From: [REDACTED]
To: [Glyn Rhonwy Pumped Storage Scheme](#)
Cc: [REDACTED]
Subject: Deadline 5 submission for Waunfawr residents
Date: 21 June 2016 11:59:39

Dear Stuart Cowperthwaite

I am writing this on behalf of a large number of residents in Waunfawr, particularly those nearby and along the Q1 access route, Cefn Du Road.

### Indicative Elevations & Section of Penstock Configuration (Revision 1)

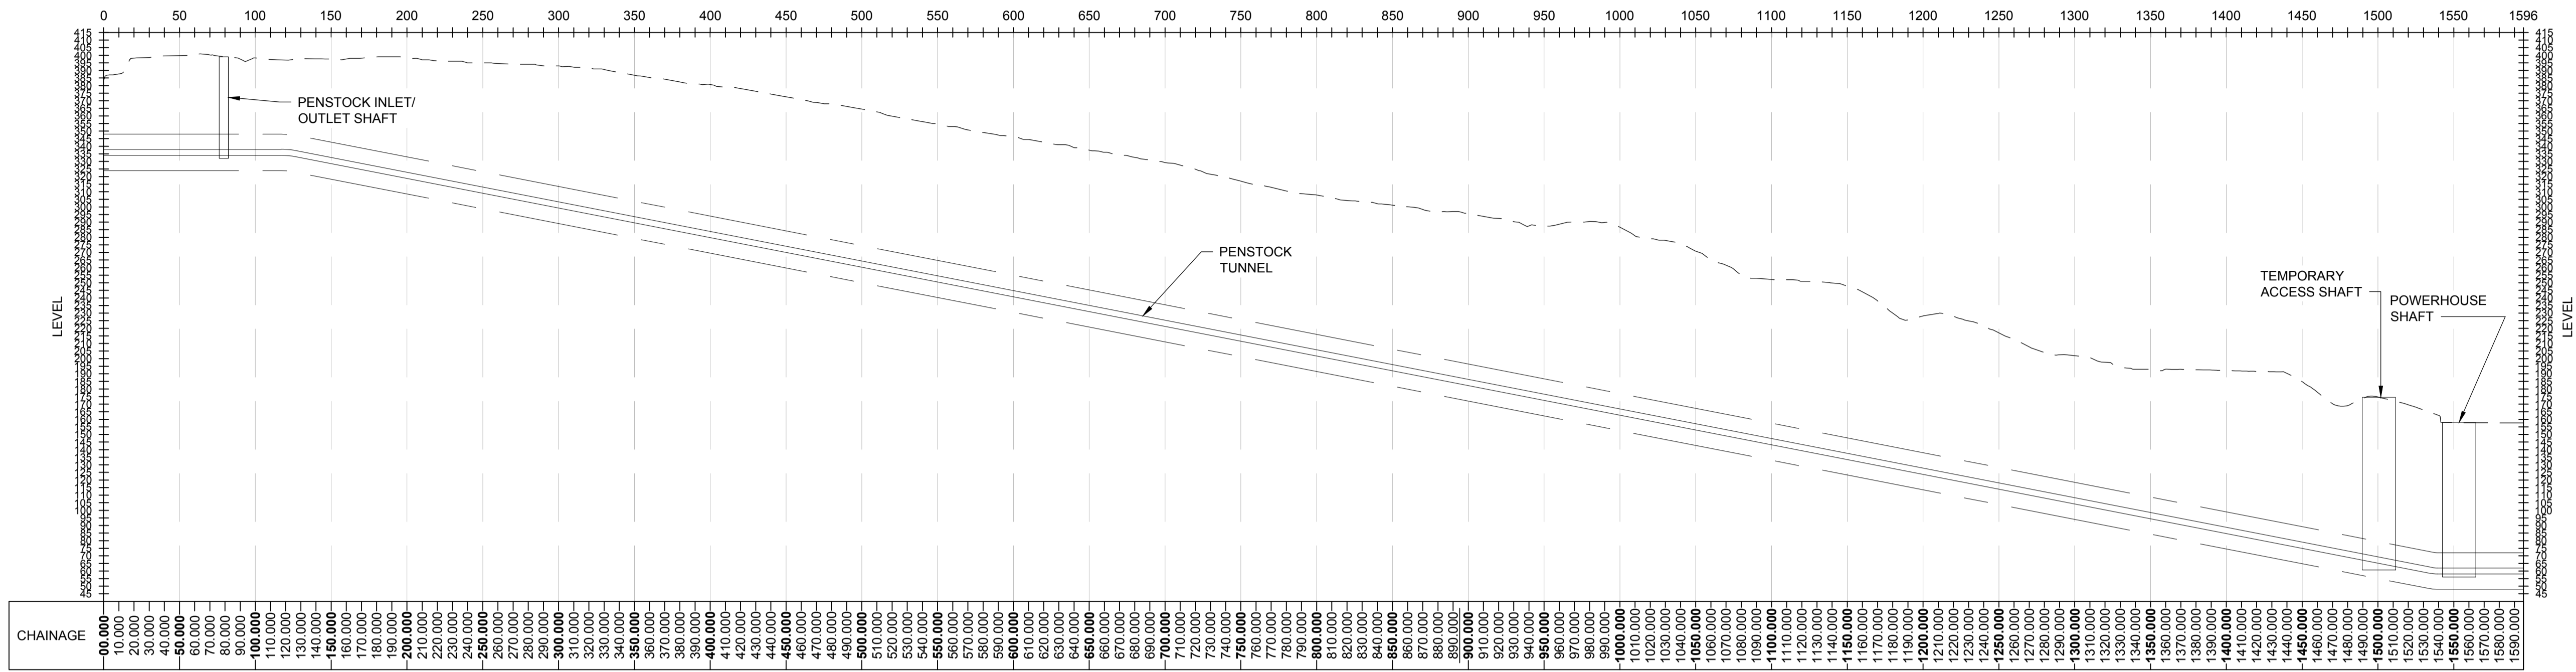
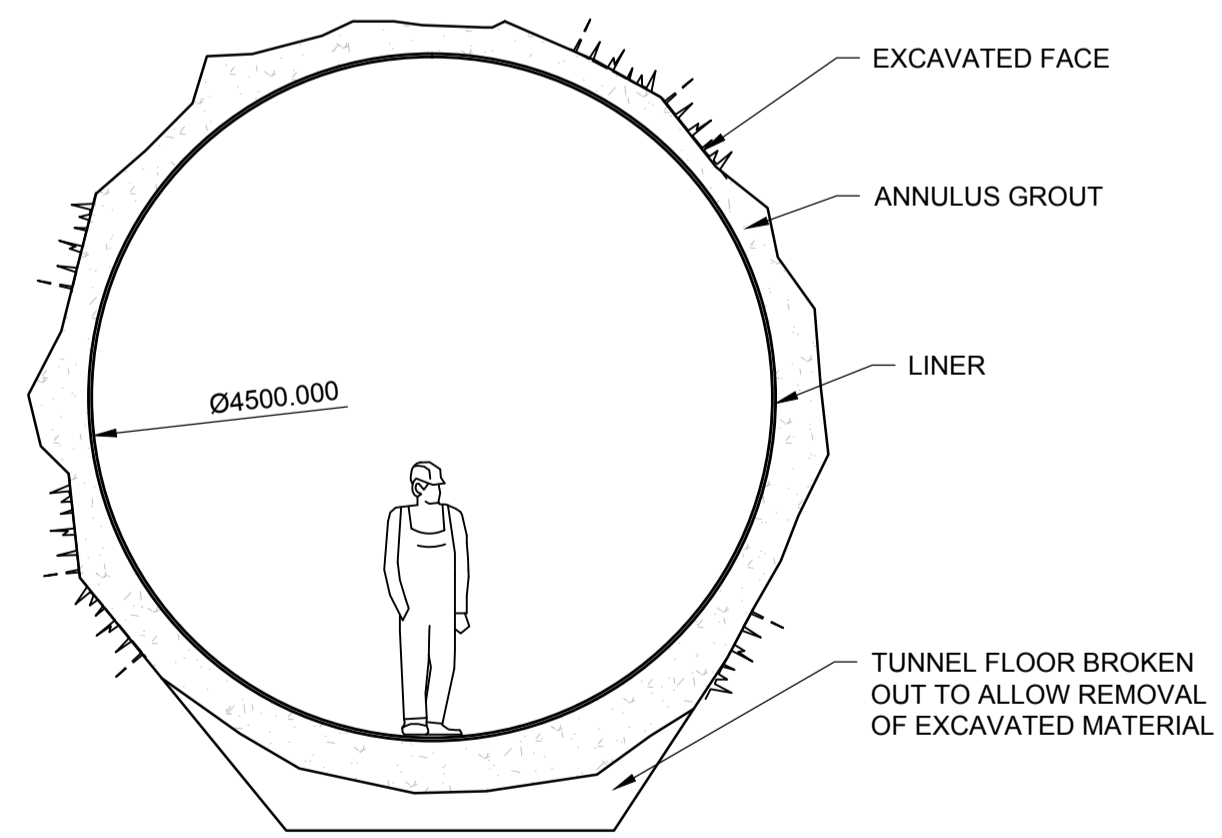
We raise again the issue of why there is a need to use Cefn Du Road at all. If access to the penstock is required at regular intervals to provide adequate ventilation, spoil removal, concrete lining, etc, as indicated by expert analysis, then this access would be best designed to also provide the access to Q1 from Glyn Rhonwy. We refer again to the Deadline 5 submission by Mike Vitkovitch for an example of how a viable direct access route can be constructed and the reasons why this should be the preferred option. We reject the SPH answer to this question (that "there is always someone who has a better idea..") as they never properly investigated this option.

2. An access route along the penstock will be required in order to support excavation and spoil removal and this could double up as Q1 access. Landowners are sympathetic to this and none of the consultees have an issue with such a route as long as it avoids major archaeological and ecological sites of importance (please see Deadline 5 submission by M Vitkovitch and Deadline 4 submission by Jane Huuse).

If a second tunnel is needed, or a wider tunnel than required solely for the operational phase is needed, how does that impact on the volume of spoil produced and the time and working hours taken to construct the tunnel(s) and disposal of the spoil?
